**Recommendation:** Refuse

**Proposal:** Erection of a double garage to the front of the dwelling to allow for overnight parking spaces (resubmission of 22/00332/F)

DRAWING:
Plans and Elevations

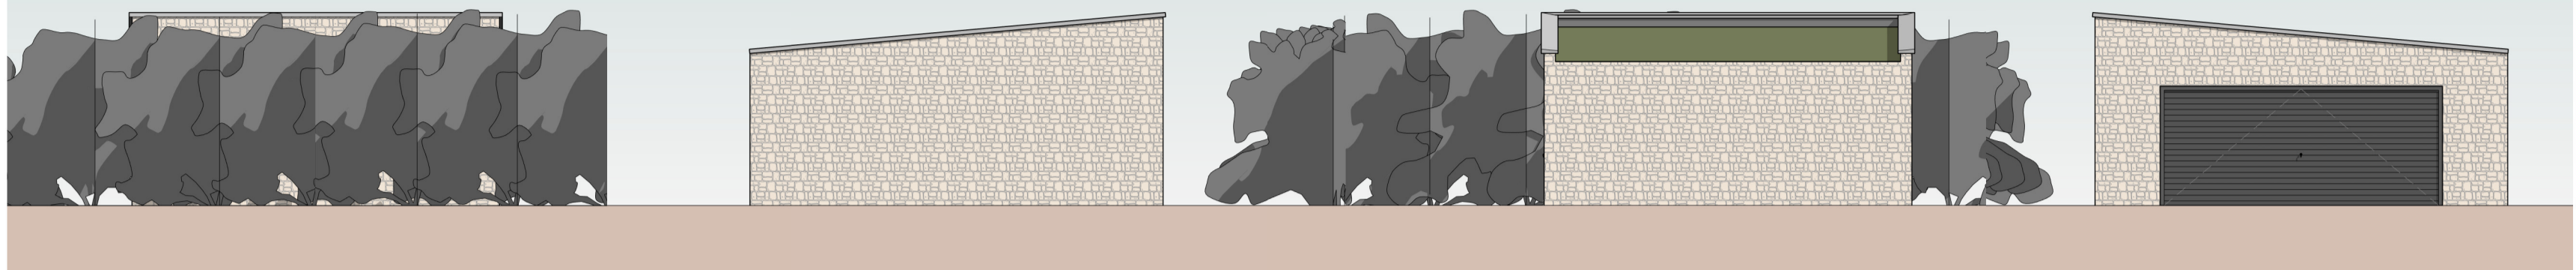
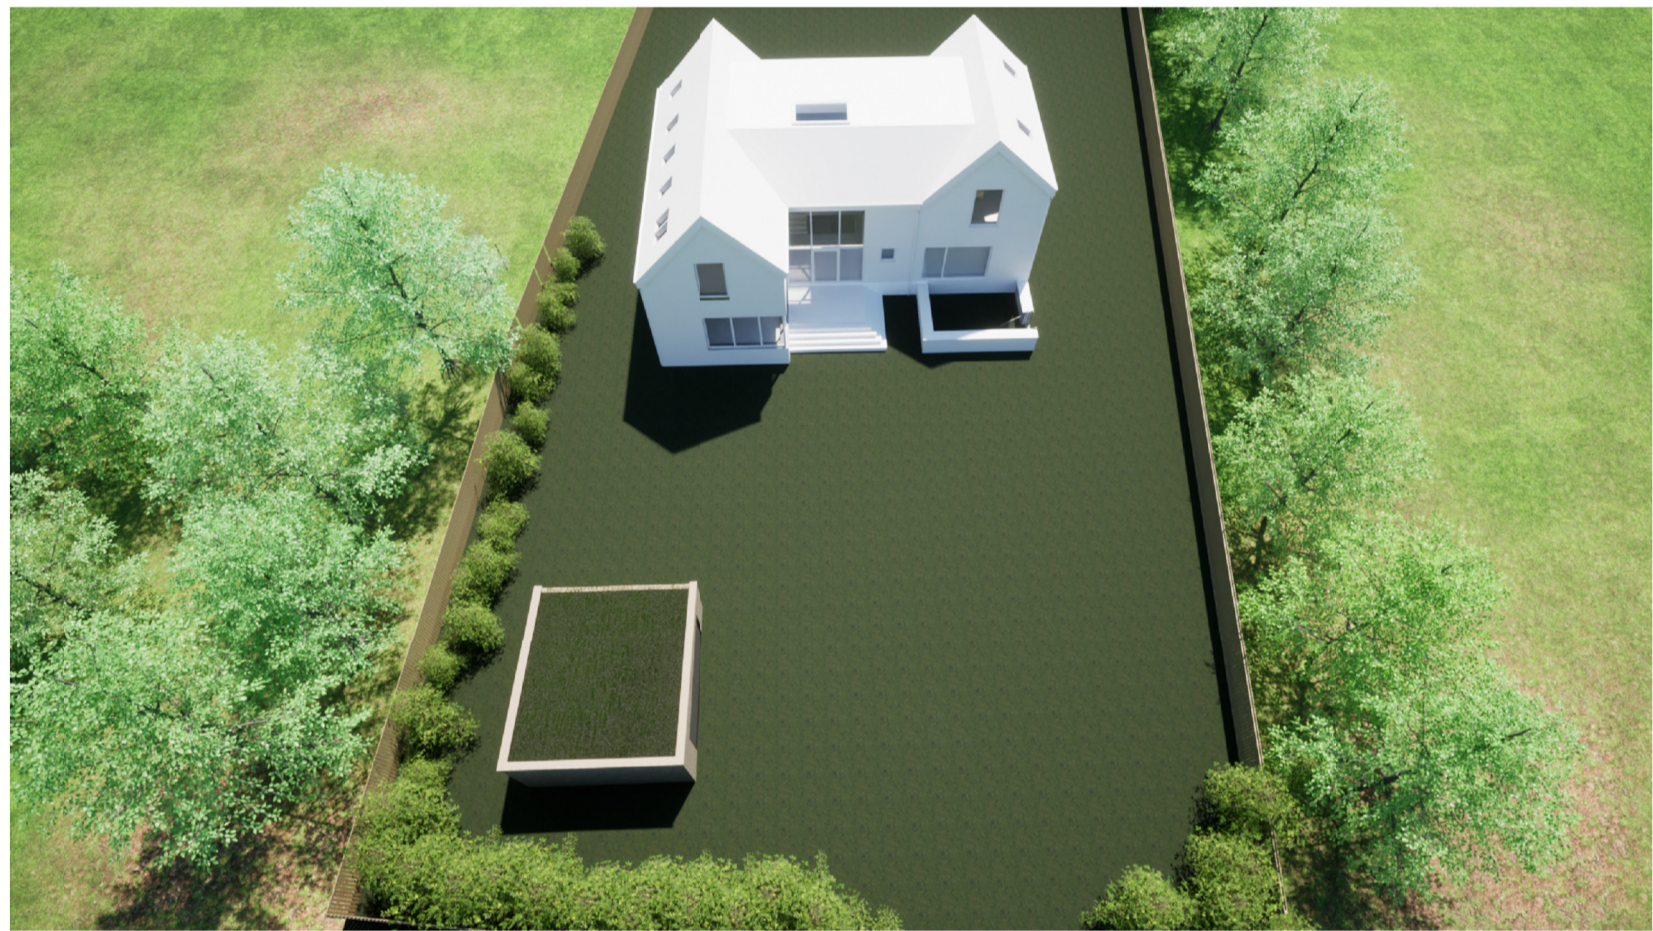
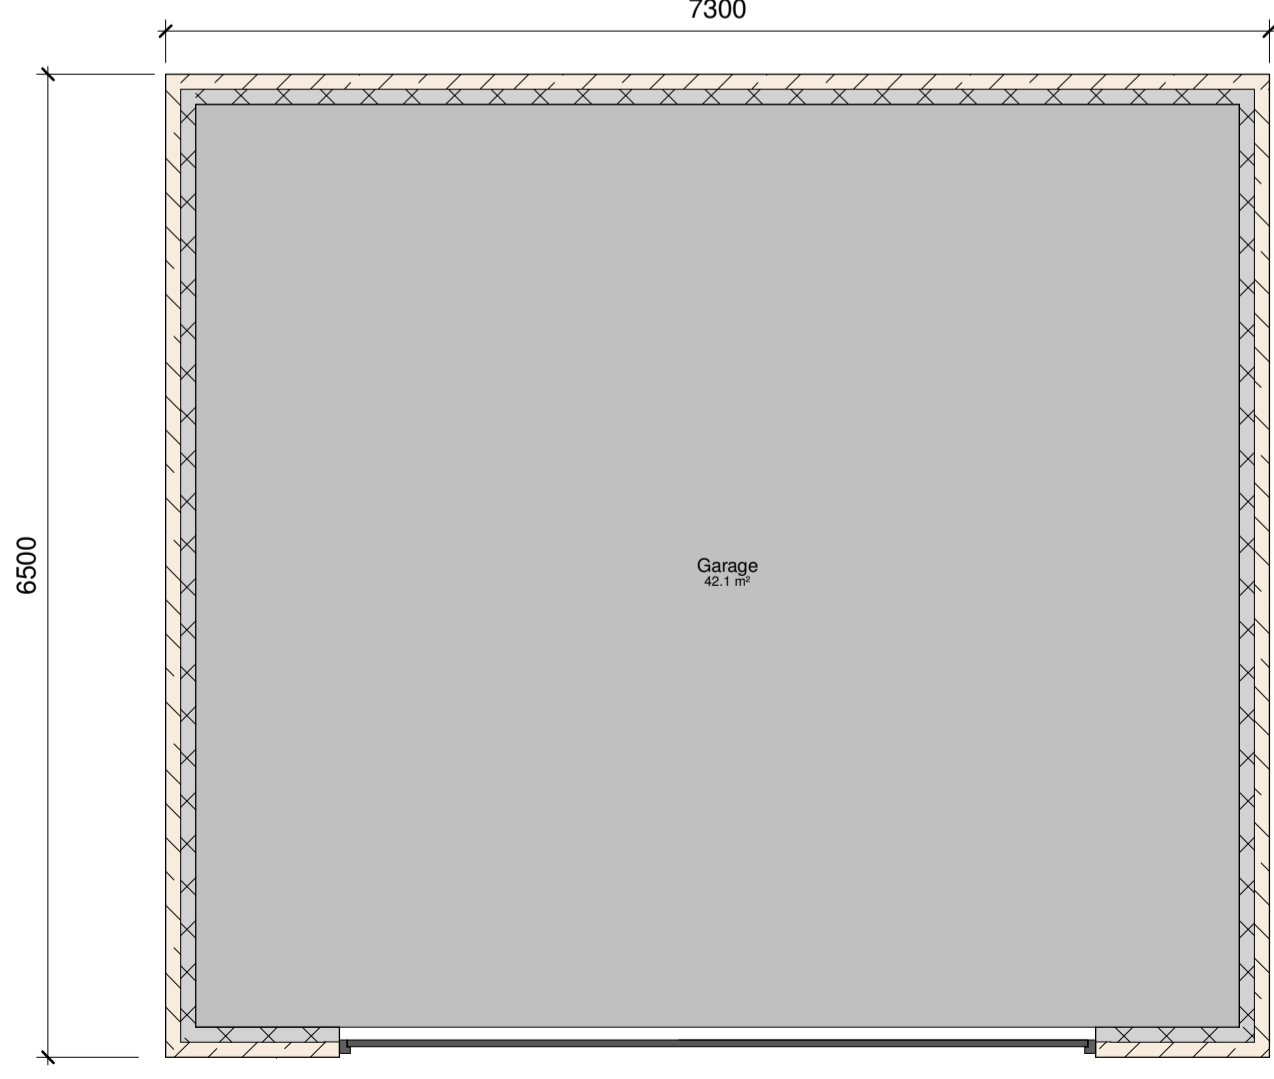
It is noted that there are no other significant built features within the front garden of properties within this area of the village, and as such the proposed scale and location of the garage is considered not to be in keeping with the character of the area, nor would it preserve or contribute positively to the setting of the surrounding conservation area.

While it is acknowledged that the design of the garage has been amended since the previous submission (ref: 22/00332/F) with a reduction in the overall height of the building, which allows it to be better screened from the front boundary, the garage would still be visible and apparent from the public domain, especially when viewed from the west of the site. It is therefore not considered that the amendments overcome the issues outlined in the previous application.

It is considered that, by reason of its scale and siting, the proposal would result in a visually incongruous form of development that would adversely affect the character and appearance of the area and would result in harm to the significance of heritage asset through the change that would occur to its setting.

1. By reason of its scale and siting the proposed garage would result in a visually incongruous form of development that would adversely affect the character and appearance of the area and would result in harm to the significance of heritage asset through the change that would occur to its setting. The proposal is therefore contrary to Policy ESD15 of the Cherwell Local Plan 2011-2031 Part 1, saved Policies C28 and C30 of the Cherwell Local Plan 1996 and Government guidance contained within the National Planning Policy Framework.
